ROLLIN RIDGE Filing No. 1 Construction Drawings El Paso County, Colorado

ROLLIN RIDGE - FILING NO. 1

Construction Drawings_V1.pdf Markup Summary

**CHERRY CROSSING DRIVE
 PLAN & PROFILE**

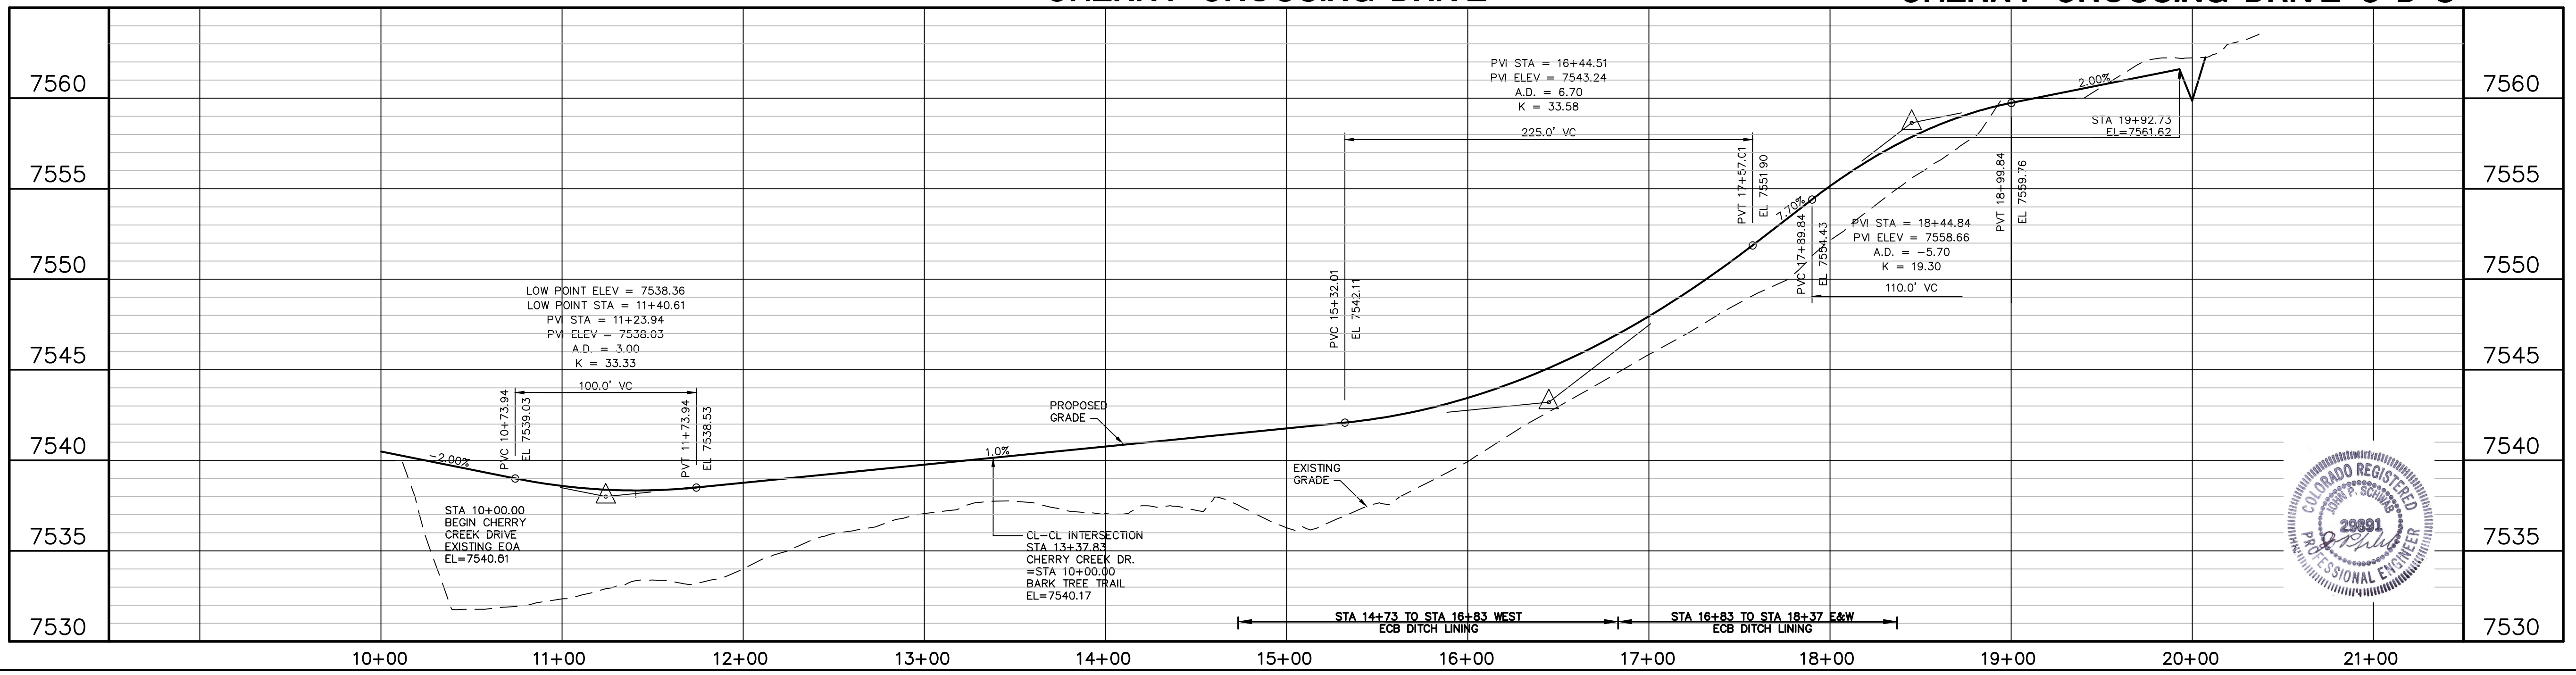
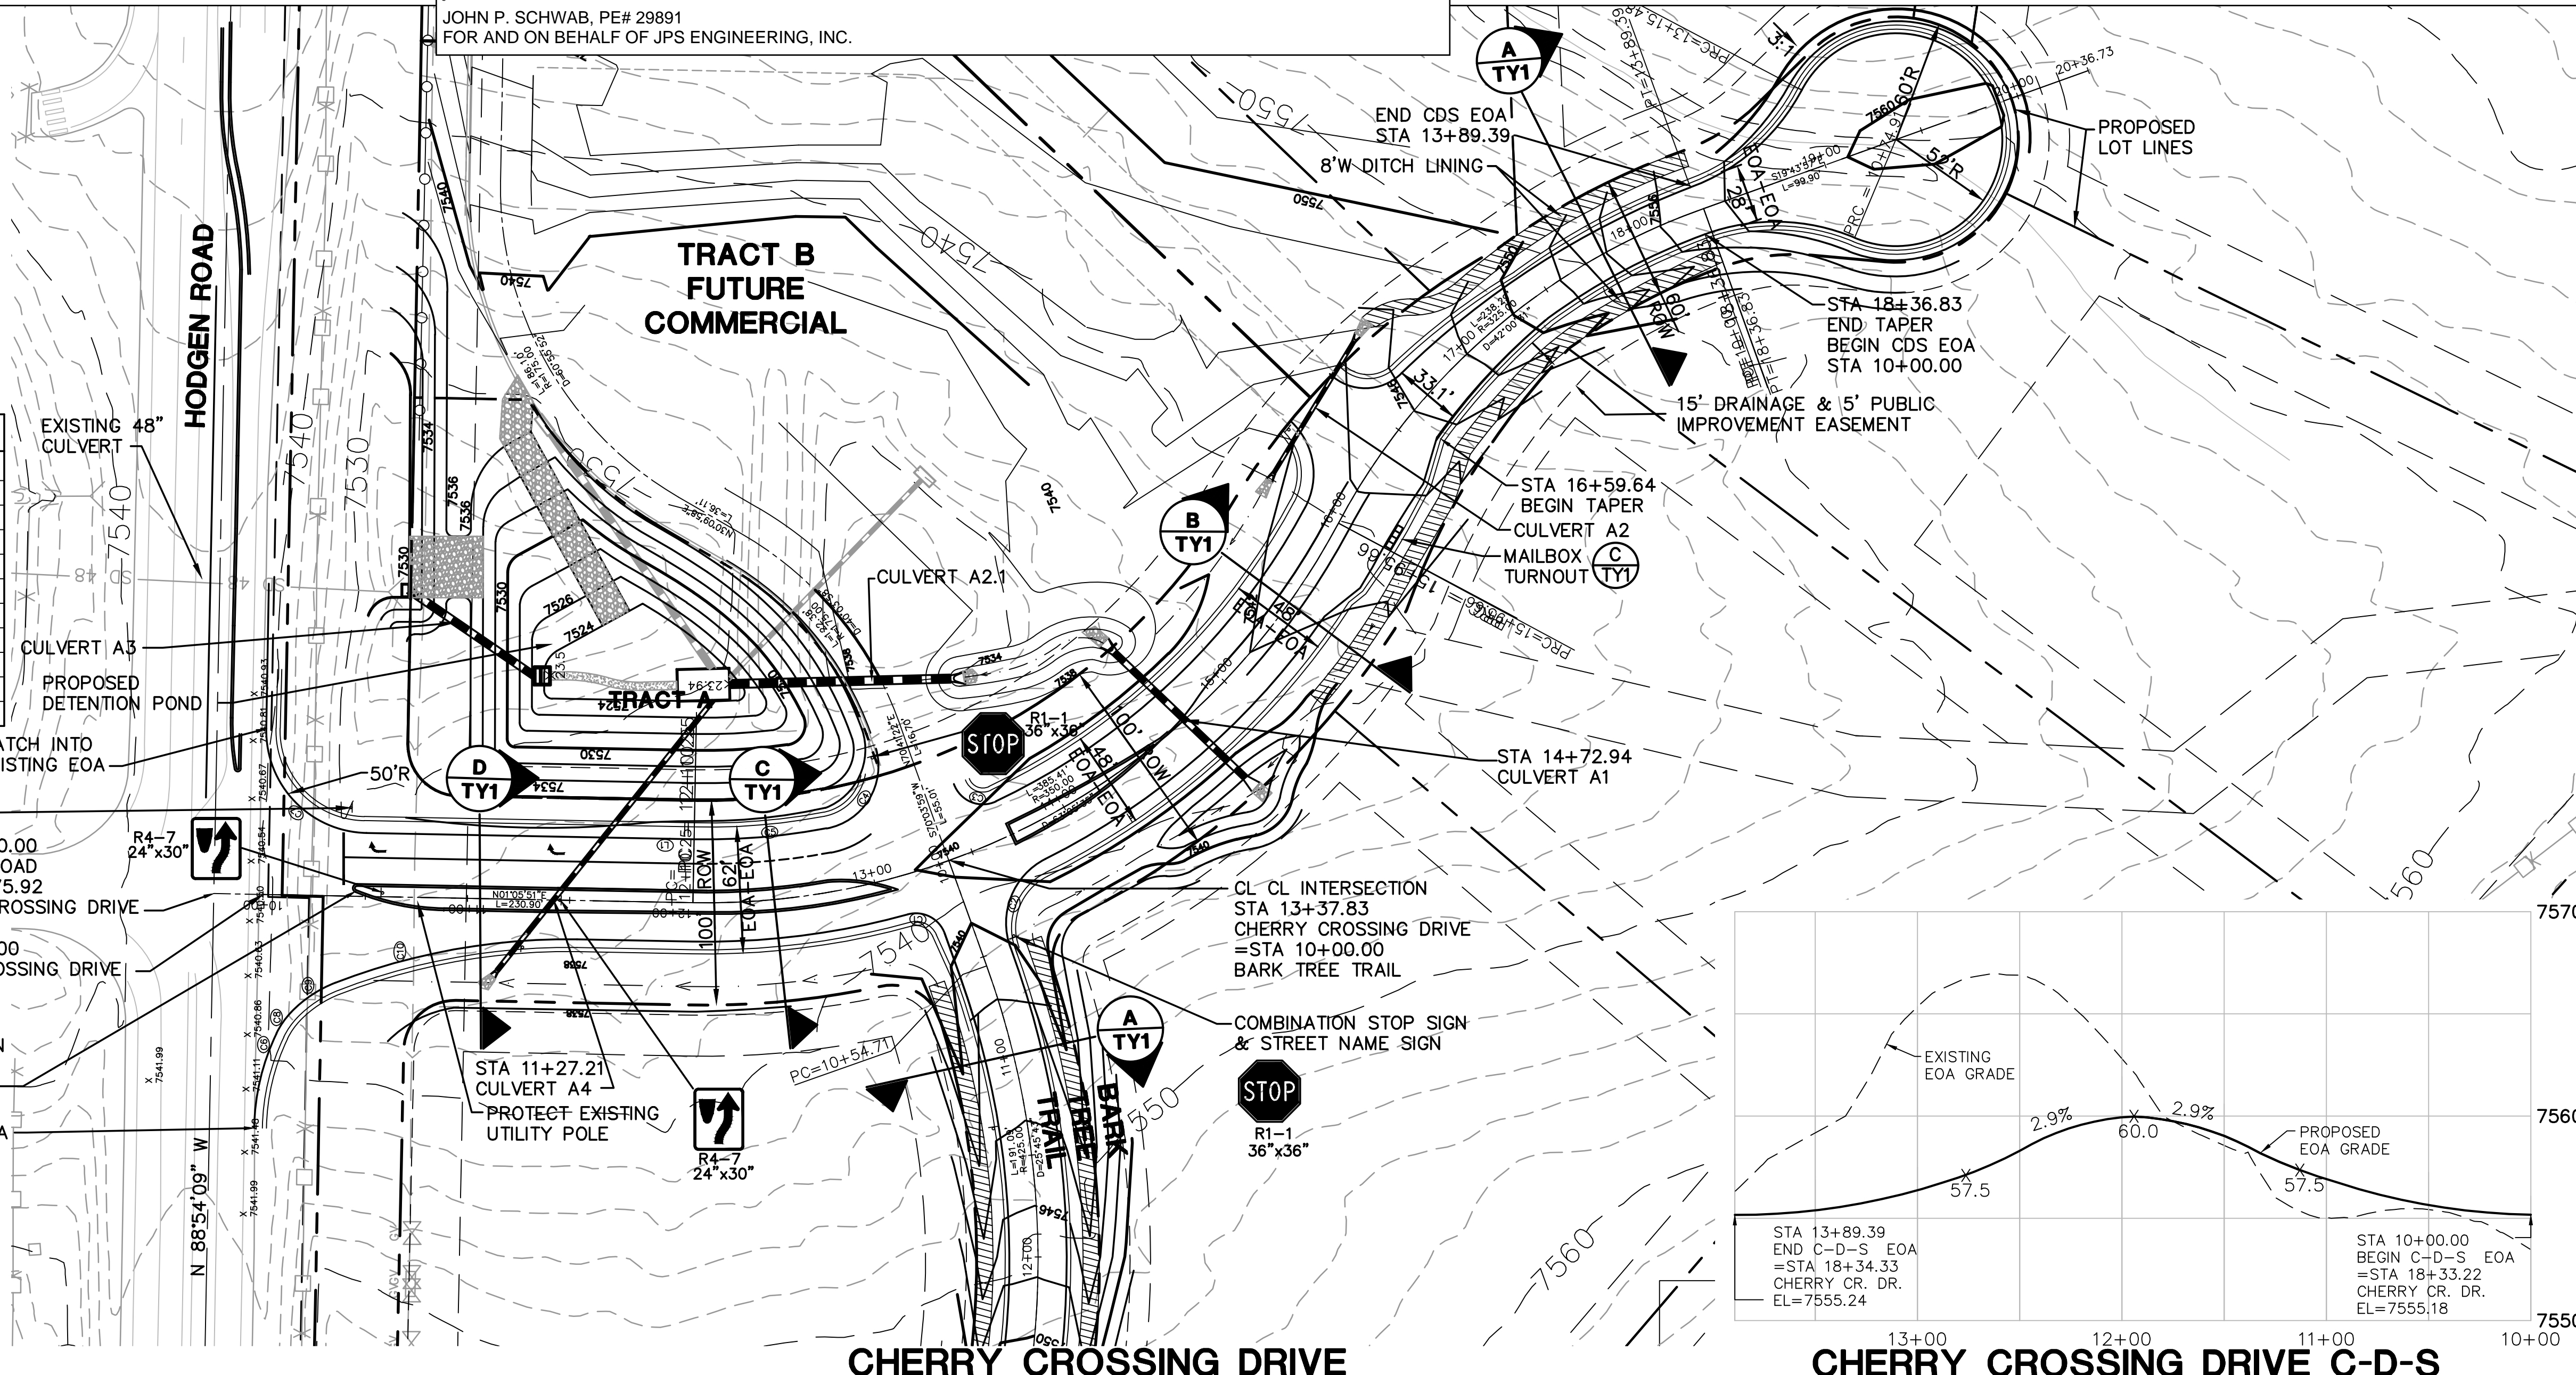
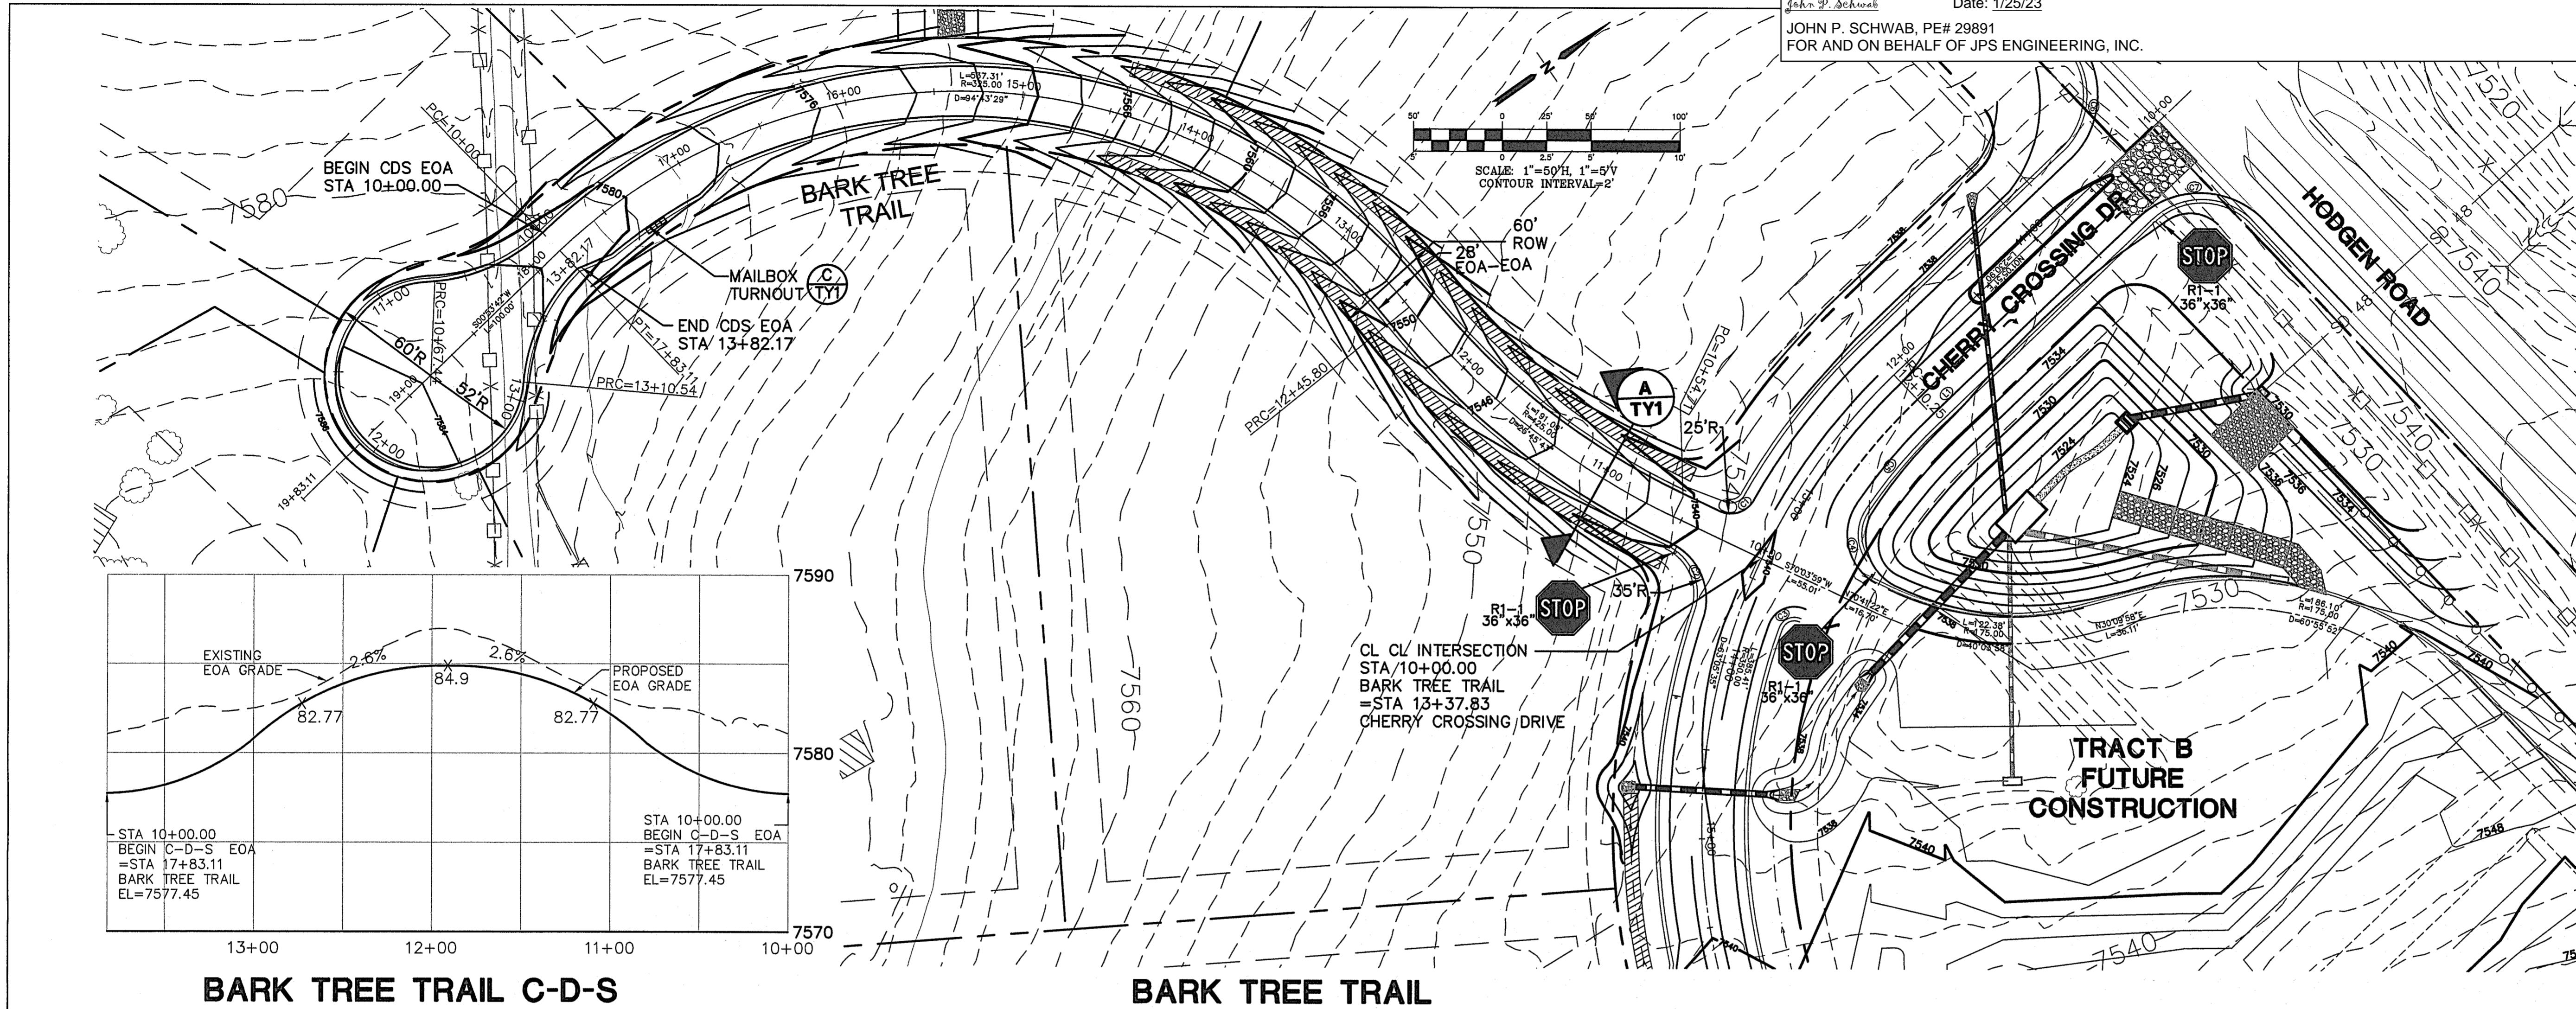
Identify the MUTCD sign designation and size for all the stop signs.

Review the plan view and adjust all text overlap and text size for legibility. See items highlighted in yellow on this sheet for examples.

Install the Keep Right sign at both ends of the island

In the typical cross section, identify the median island surfacing. Is this paved or landscaped? If landscaped, a landscape agreement is required.
